REQUEST

Current Zoning: R-6MF(CD) (multi-family residential, conditional)
Proposed Zoning: R-22MF(CD) (multi-family residential, conditional)

Approximately 14.8 acres located on the west side of Krefeld Drive, east of Monroe Road, and west of East Independence Boulevard

The petition proposes to develop the site with up to 320 multi-family dwelling units on the vacant site in southeast Charlotte, east of McAlpine Creek Park.

**RZ-1.0**

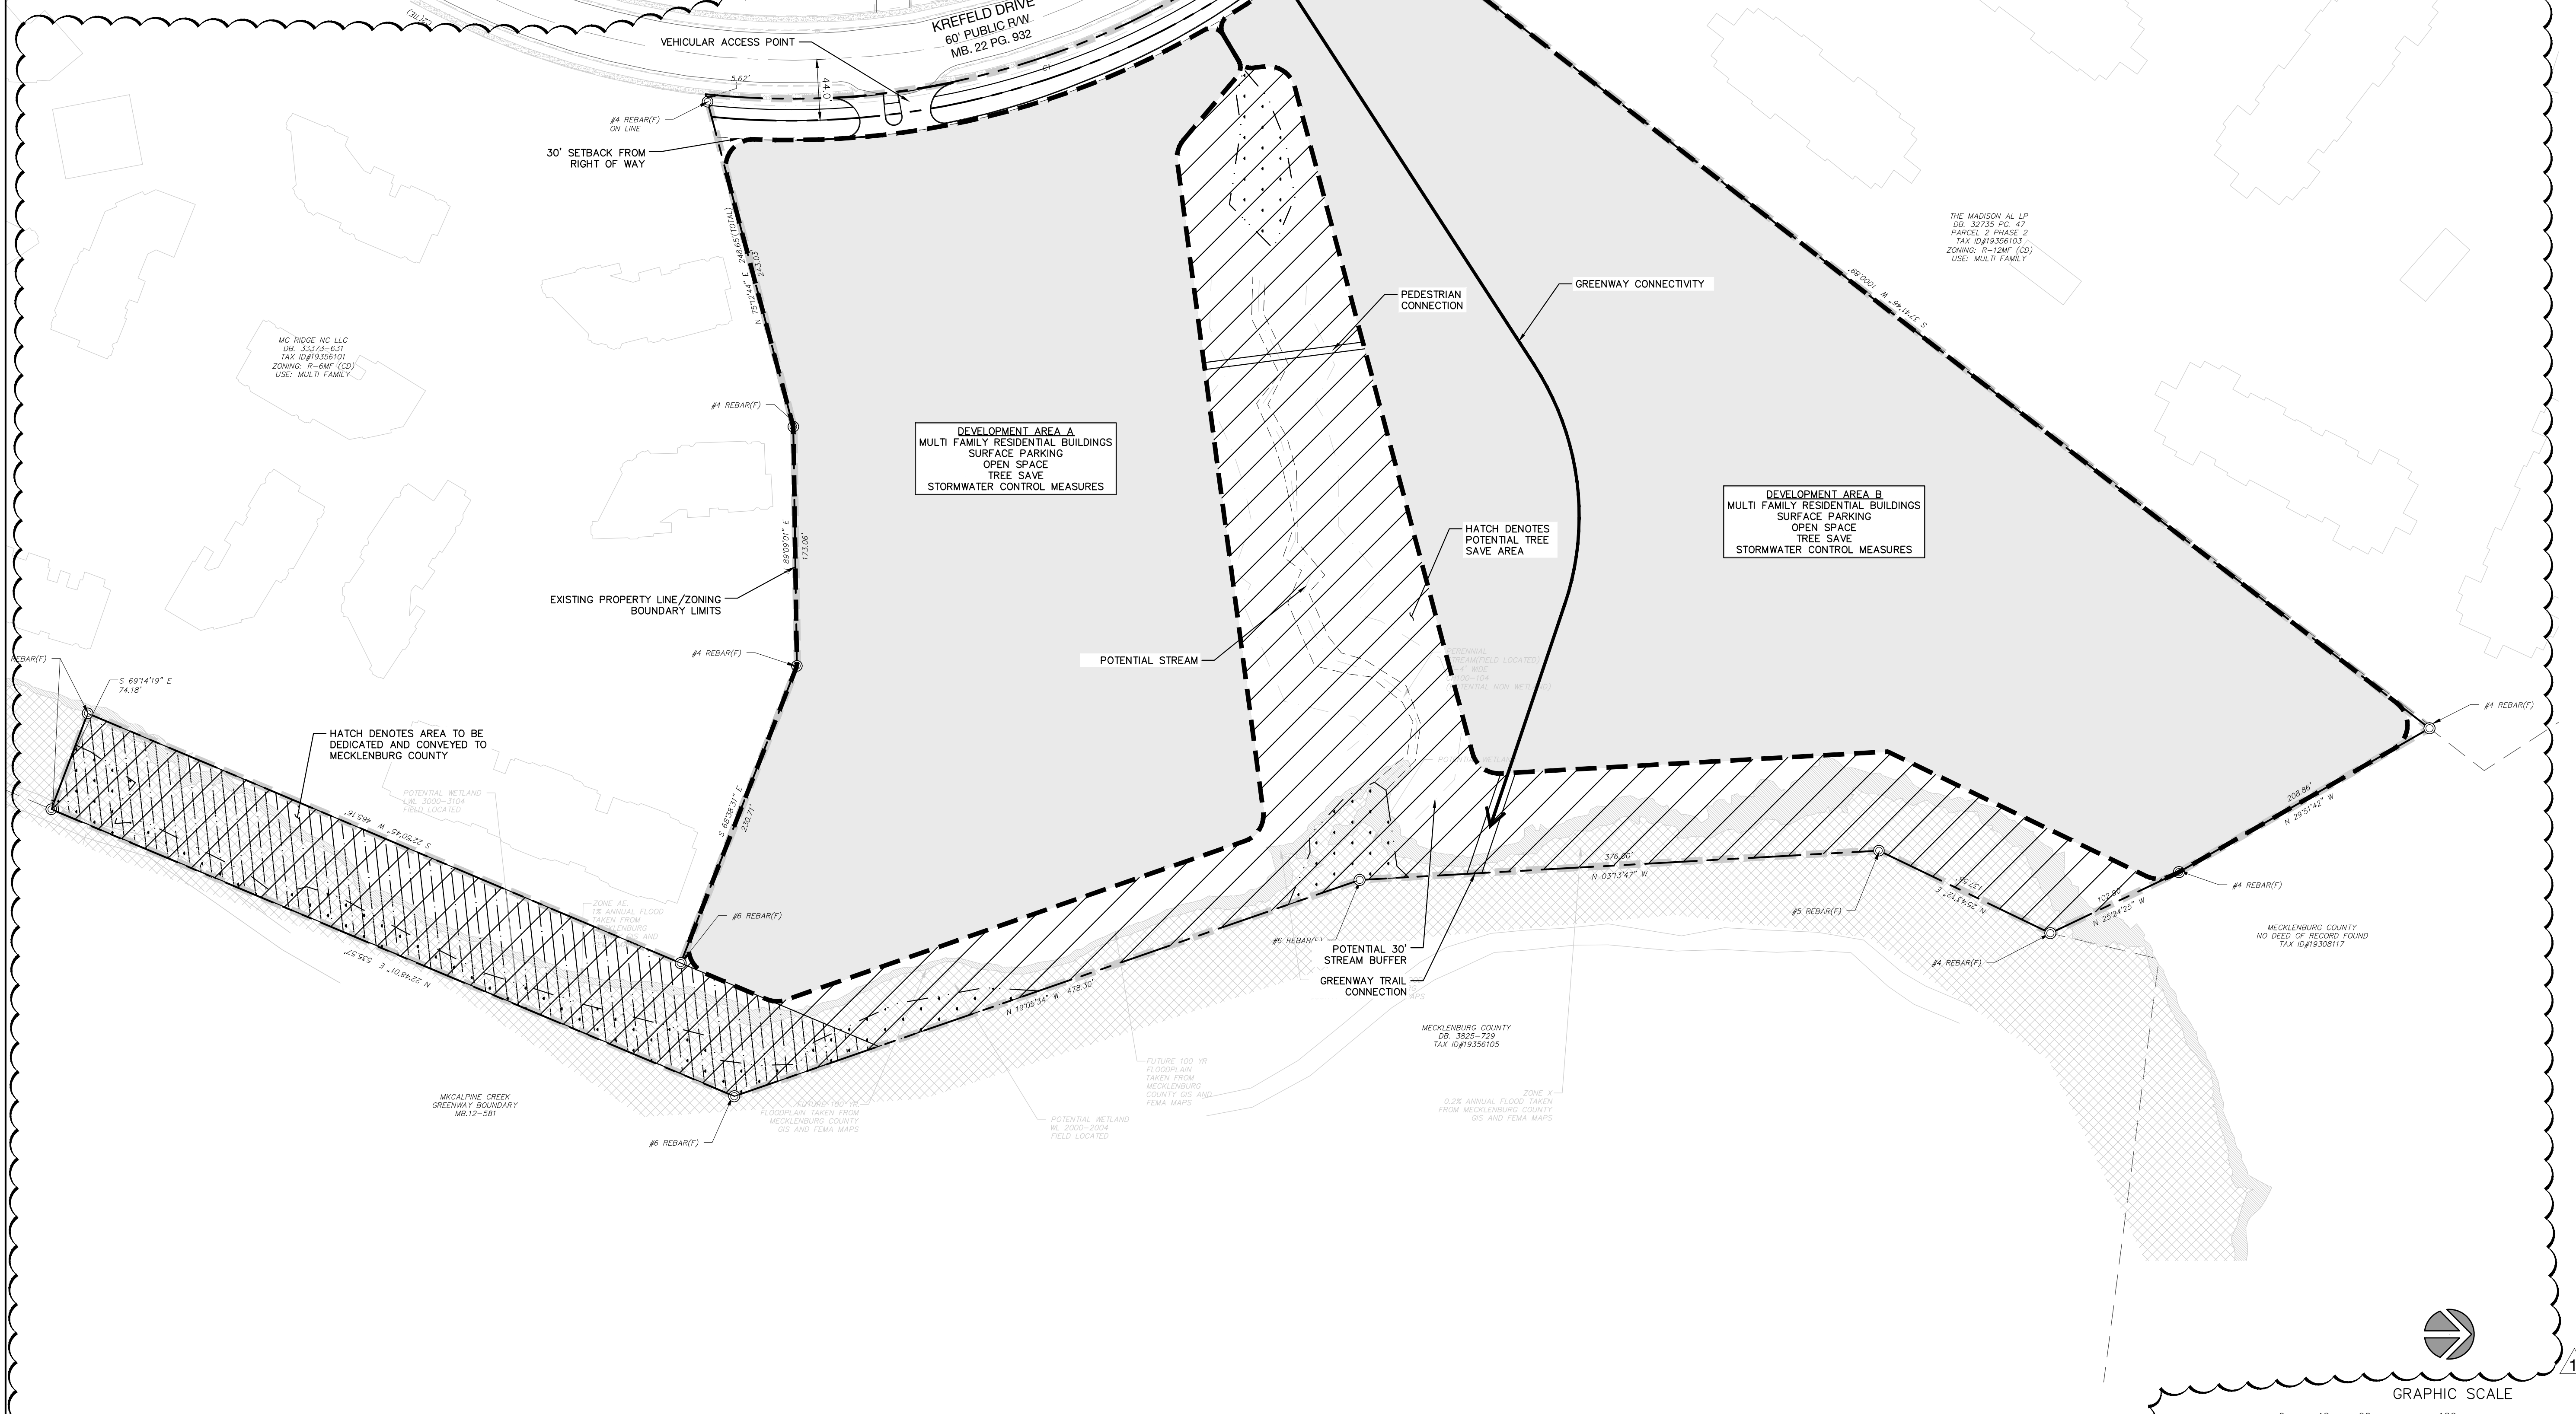
2. Clarify intent of trail connection shown on plan and noted in Park Dedication Note 1. The way the note reads now it sounds as if only residents of the proposed project would be able to use the connection. Planning staff requests the note be revised to include a public access easement so other residents along Krefeld could access the park.
3. Adjust north arrow to match site orientation.
4. Amend Streetscape, Buffers, Yards, and Landscaping Note 4 to state the "Solid waste facilities will be provided as required by Solid Waste, exact locations to be determined during permitting."
5. Amend the Development Data table to include the minimum % of open space required.
